## Sheringham and Dudgeon (Windfarm) Extension Projects

### Perenco UK Limited Response to Examiner Deadline 1

Figure 6.1: SEP and DEP Asset Overview

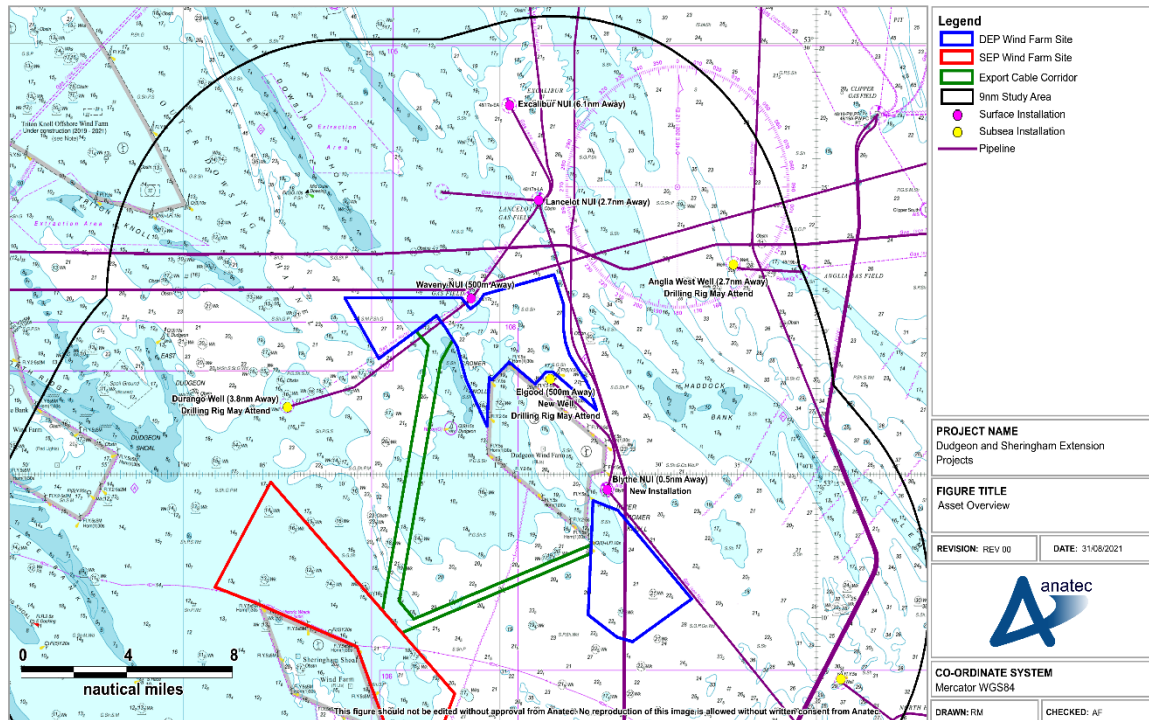
- The space required for flying on instruments (instrument meteorological conditions or IMC), would be “at least 2.5nm clear of obstacles for take-off (9nm for an approach), so IMC access is not considered further”.
- “If wind turbines were built up to the boundary, within 500m of the platform, then CAT [Civil Aviation Transport] helicopters would be unable to access the platform for 85.4% of daylight conditions.”
- “If an obstacle free radius of circa 1nm could be provided, then approaches and take-off under Day VMC [Visual Meteorological Conditions] conditions could be conducted safely. That would increase the daylight access from approximately 14.6% to 92.3% (2020) of day conditions.”

In reaching these conclusions, Anatec have made some assumptions that PUK does not consider to be valid. These are:

- Flights can be conducted when all Civil Aviation Authority (CAA) minimum conditions are met.
  - In fact Helicopter Operators impose more onerous requirements than these minimum conditions. For example, where turbines are within 3nm of a helideck, Helicopter Operators only permit flights in daylight and operating visually. The cloudbase and visibility criteria for such operations are more onerous than the CAA’s minimum requirements for flying under VMC. So, although it may legally be possible to fly, no Helicopter Operator would provide a service under some of the conditions assumed acceptable by Anatec. As a result, the impact of the windfarm is greater than presented by Anatec.

- The space requirements for instrument operations preclude their further consideration.
  - Whilst PUK agree that an instrumented approach (Airborne radar approach (ARA)) would require about 9nm free from obstacles, Anatec have not considered that an instrument meteorological conditions (IMC) en-route descent could be executed to the north of the Waveney NUI (away from the windfarm) followed by a low altitude approach under visual meteorological conditions (VMC) to the vicinity of the Waveney NUI. In this case, the obstacle-free radius would be defined by the greater of:

- the distance needed for a take-off with one engine inoperable; and
- the minimum separation (3nm) from wind turbines stipulated by Helicopter Operators in order to permit instrument operations.

PUK believe that an obstacle-free radius of at least 3nm would permit instrument flying to and from the Waveney NUI and thus significantly reduce the impact of the windfarm on the helicopter flights required to enable operations at the Waveney NUI, especially during decommissioning and dismantling.

- Under daylight conditions, a turn into a 0.5nm stabilised Final Approach Track can be accomplished within a total radius of 1nm around the Waveney NUI.
  - Under daylight visible conditions, aircraft are required at all times to maintain a distance of at least 500' laterally from all obstacles. The wind turbine rotors proposed for DEP North may have a diameter of up to 300m (APP-090, pg74). PUK's Helicopter Operator does not consider 1nm to be sufficient to make a turn and then establish a 0.5nm stabilised Final Approach Track whilst maintaining separation from the wind turbines and rotors. A minimum of 1.5nm around the Waveney NUI would be required for such daylight operations.

Notwithstanding the above differences, Anatec's analysis clearly shows that, unless sufficient obstacle-free space is provided around the Waveney NUI, helicopter operations would be so restricted as to make production, decommissioning and dismantling activity impossible. PUK considers that the minimum obstacle-free space that would permit some helicopter operations would be 1.5nm as opposed to the 1nm proposed by the Applicant. Flying in this minimum space scenario would however be severely restricted relative to current operations (particularly to a rig, where currently flights are not restricted to daylight hours). Anatec's analysis significantly under-states this reduction as it only considers that flying would be limited to daylight. Anatec did not consider that flights would also be limited to times when the Helicopter Operators' visibility and cloud base requirements are met (these are more stringent than current CAA minima for VMC operations). PUK believe that an obstacle-free radius of 3nm (which would allow operations based on the normal CAA minima, including instrument operations) is required to ensure that the restrictions to flying do not have too adverse an impact on Waveney NUI operations.

Whilst the Applicant is not expected to determine the placement of wind turbine generators until after approval of the DCO, recognising that wind turbine generators will have a minimum separation of 1.05km (cf APP-090, pg 74), it may be possible to accommodate one wind turbine generator within the 3nm radius PUK believes is necessary. Such an approach would mitigate the impact on the Applicant of facilitating coexistence with PUK.

- obstacle-free airspace of at least 3nm around the Waveney platform
- a corridor of at least 1km width along the route of the Durango to Waveney pipeline which is clear of temporary and permanent surface obstacles.
